APPLICATION FOR REMOVAL OR VARIATION OF A CONDITION FOLLOWING GRANT OF PLANNING PERMISSION (Ref: 20/02247/FULL). TOWN AND COUNTRY PLANNING ACT 1990. PLANNING (LISTED BUILDINGS AND CONSERVATION AREAS) ACT 1990.

REGENCY HOUSE, 1-4 WARWICK STREET, LONDON, W1B 5LT

On behalf of our client, Maslow's ("the Applicant"), we enclose herewith a Minor-Material amendment application to planning permission ref: 20/02247/FULL, which was approved on 18 December 2020. The approved description of development is:

Drawing Number
MS-DCM-07-DW-PL-41207
 Drawing Status
PLANNING
 Revison
A

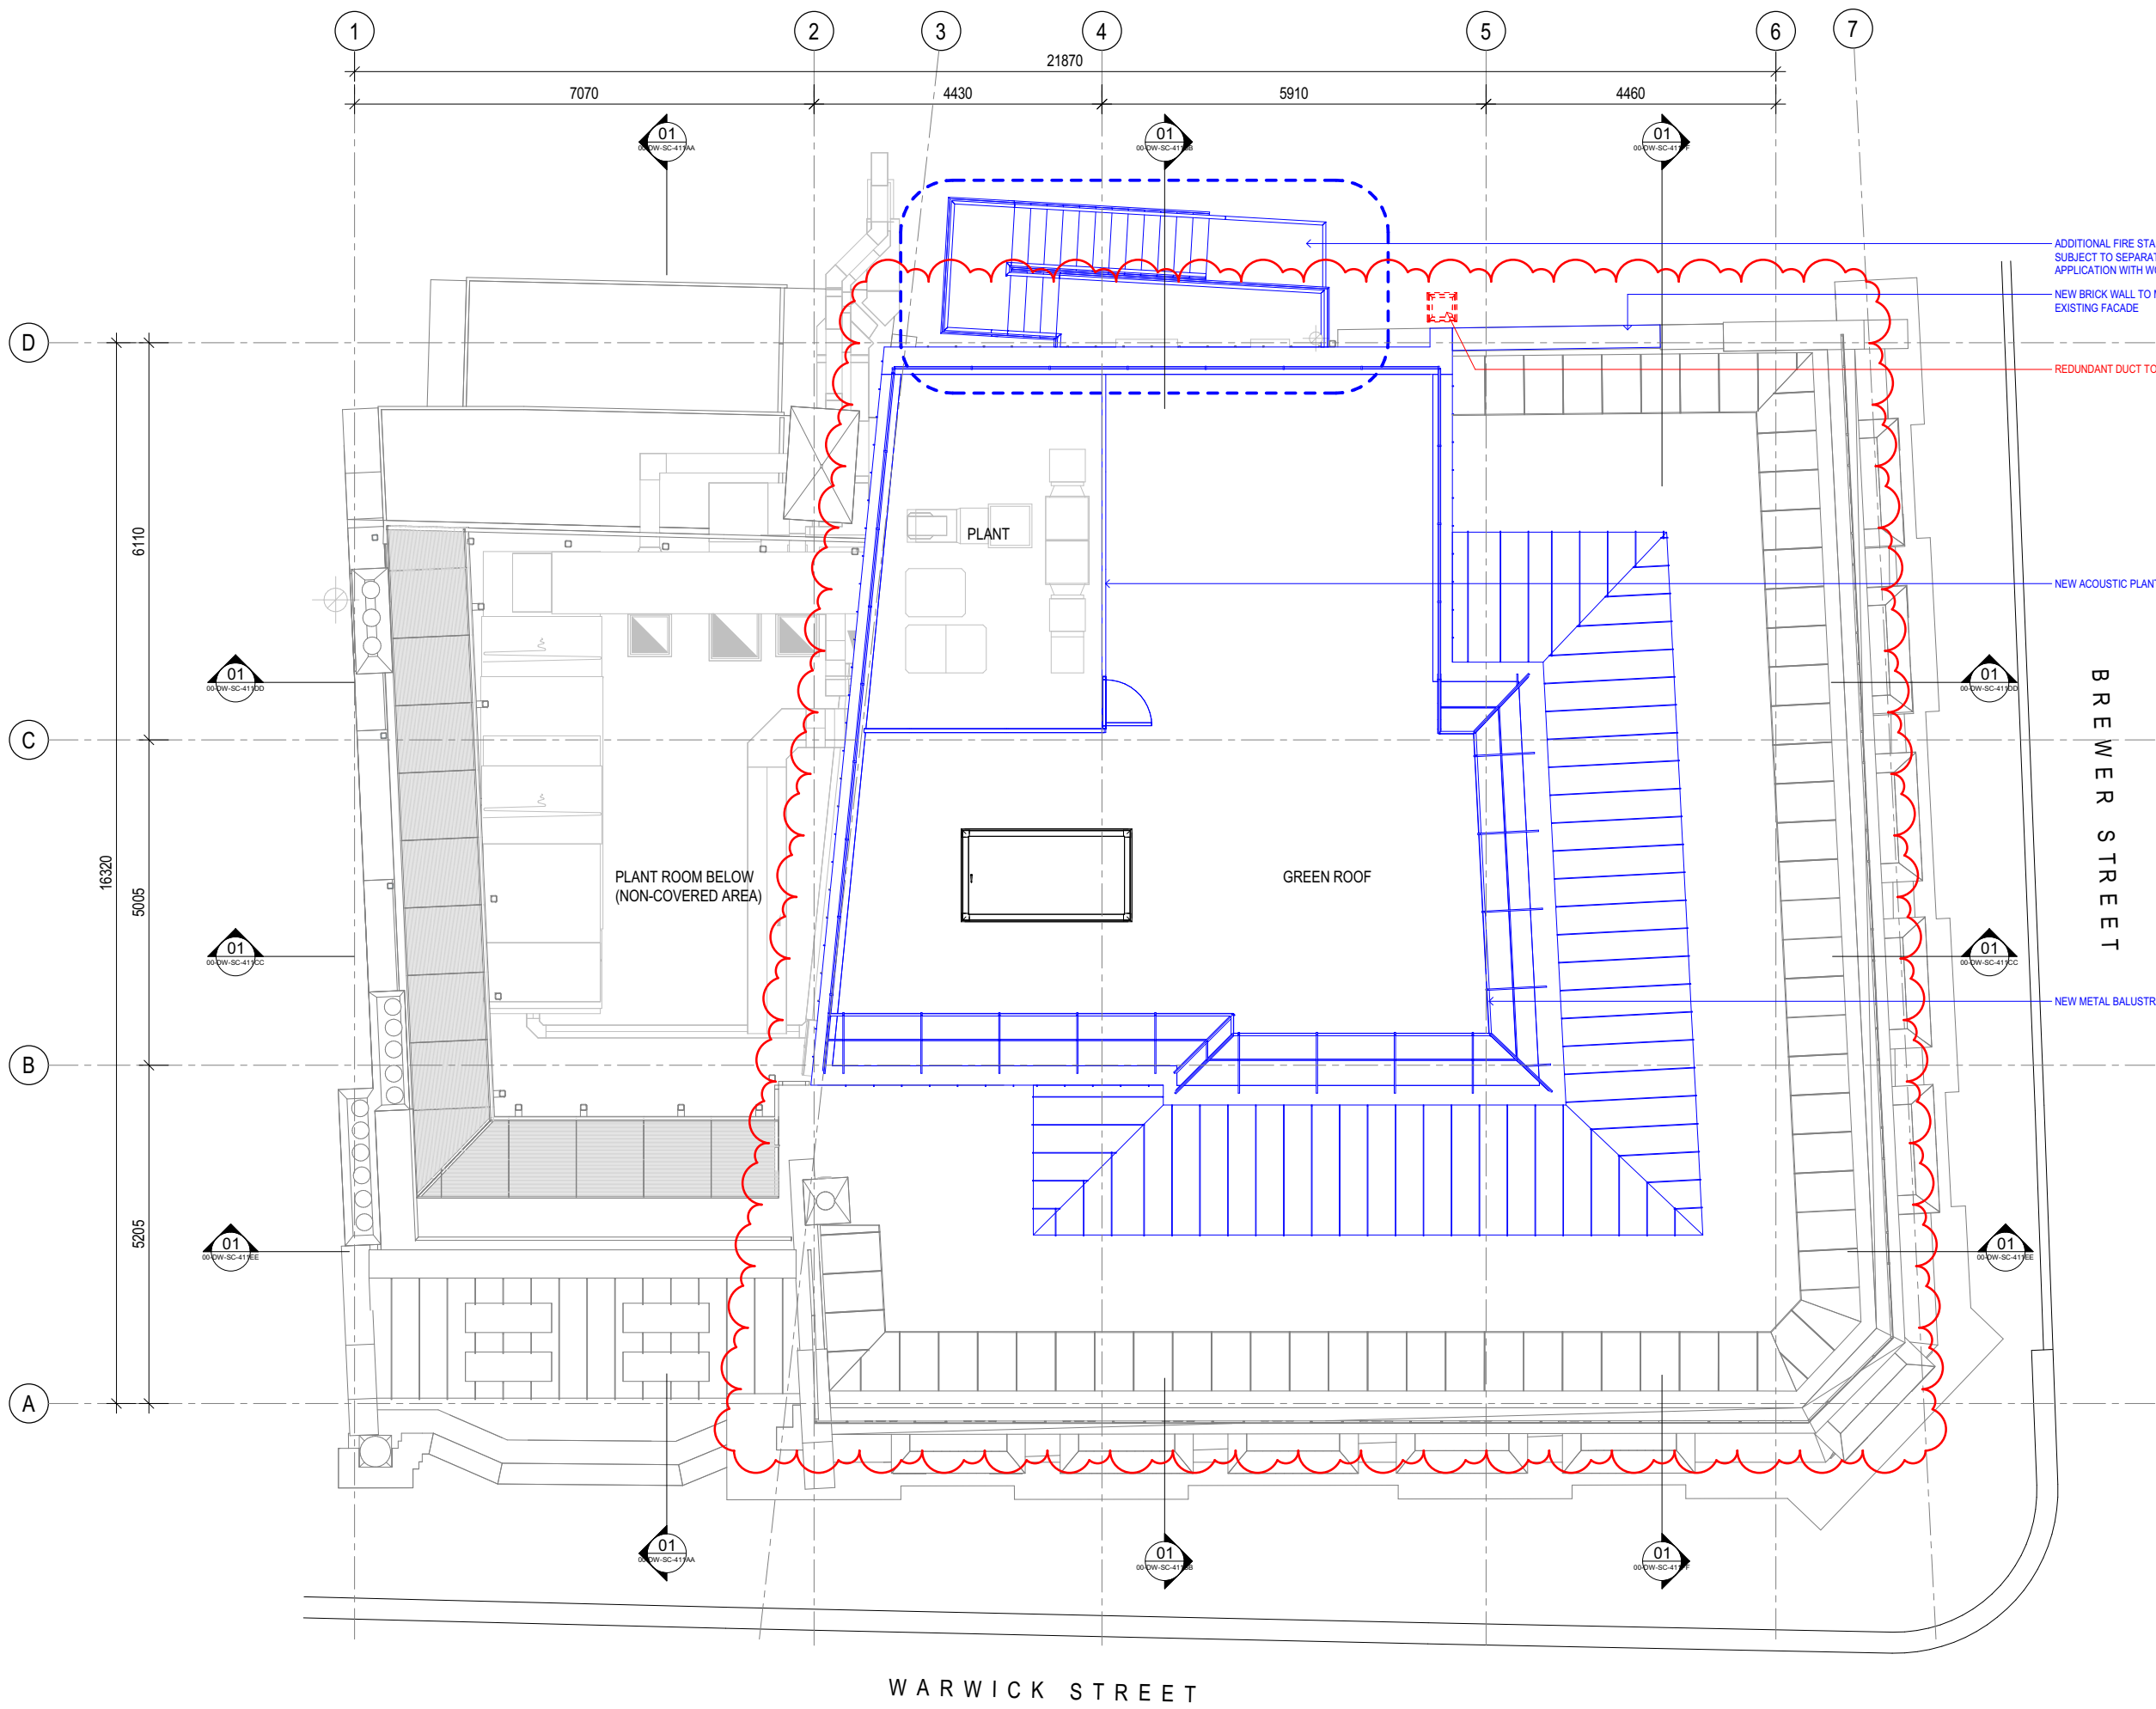
- Removal of the roof overhang to the level 06 extension, providing a more open rooftop terrace.
- Introduction of a 45-degree balustrade to level 07 rooftop which follows the building line from level 06. Item is not visible from street level.

- Additional plant with associated acoustic plant screening erected on level 07. Item is not visible from street level.

The proposed introduction of the 45-degree angled balustrade to level 07 follows the consented roofline from level 06. This proposal is not visible from street level as shown in the MMA report. Likewise, the proposed plant screen at level 07 is also not visible from street level.

Drawing Number Revision
MS-DCM-06-DW-EL-411SE A
 Drawing Status
PLANNING

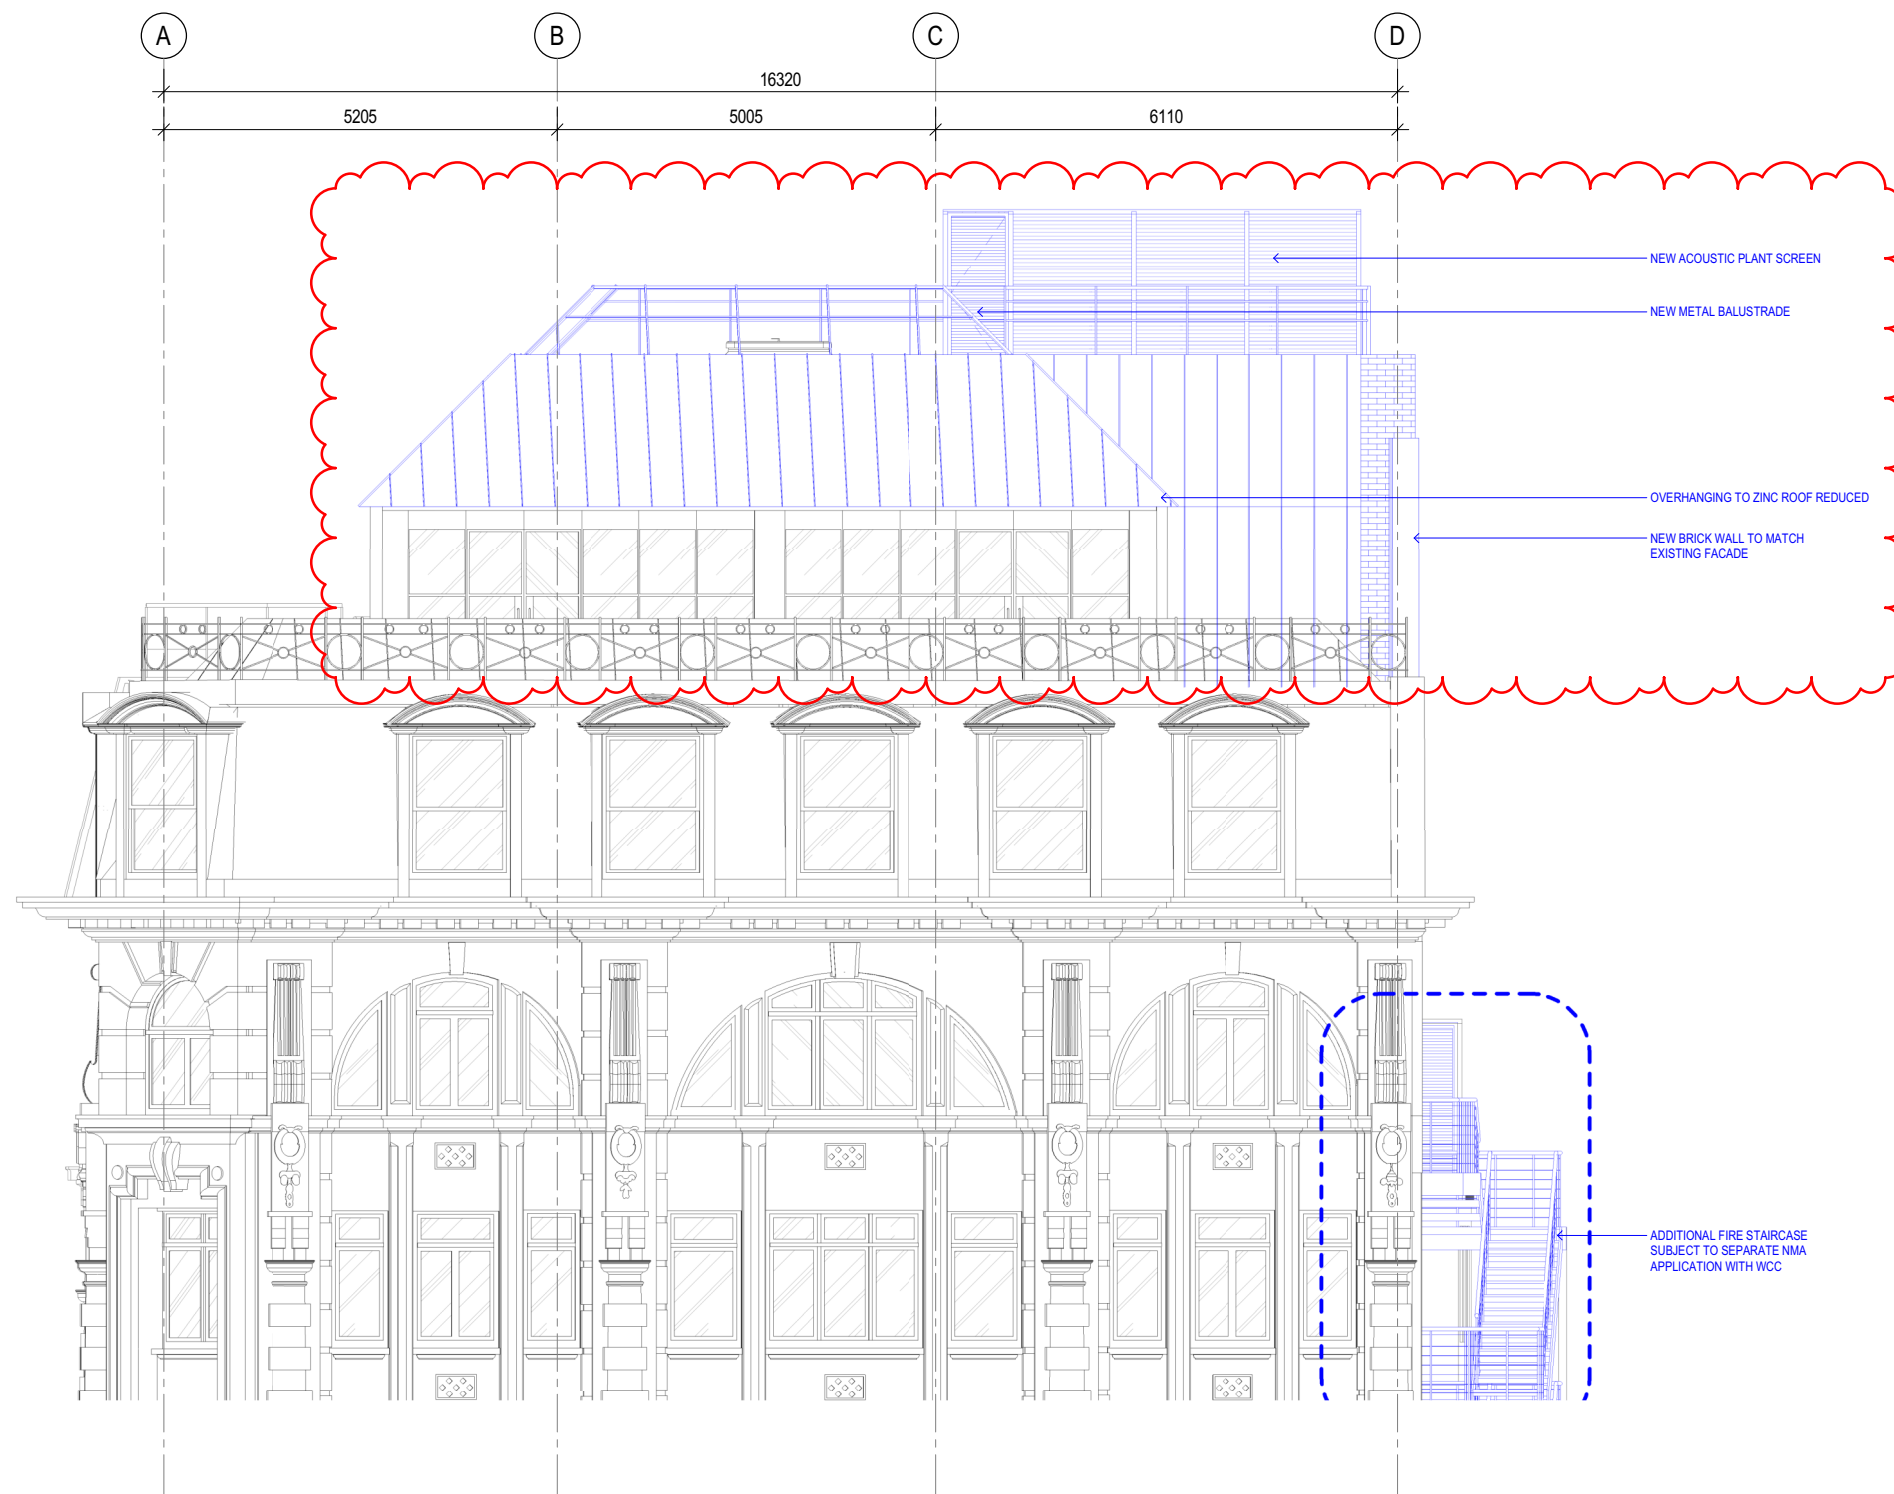
The accompanying MMA report sets out several shortcomings with the consented terrace design. The proposed removal of the roof overhang would significantly improve the openness and usability of the terrace. The design team have worked to develop a proposal that would preserve the character and appearance of the Soho Conservation Area, whilst being considerate to the Applicants design requirements.
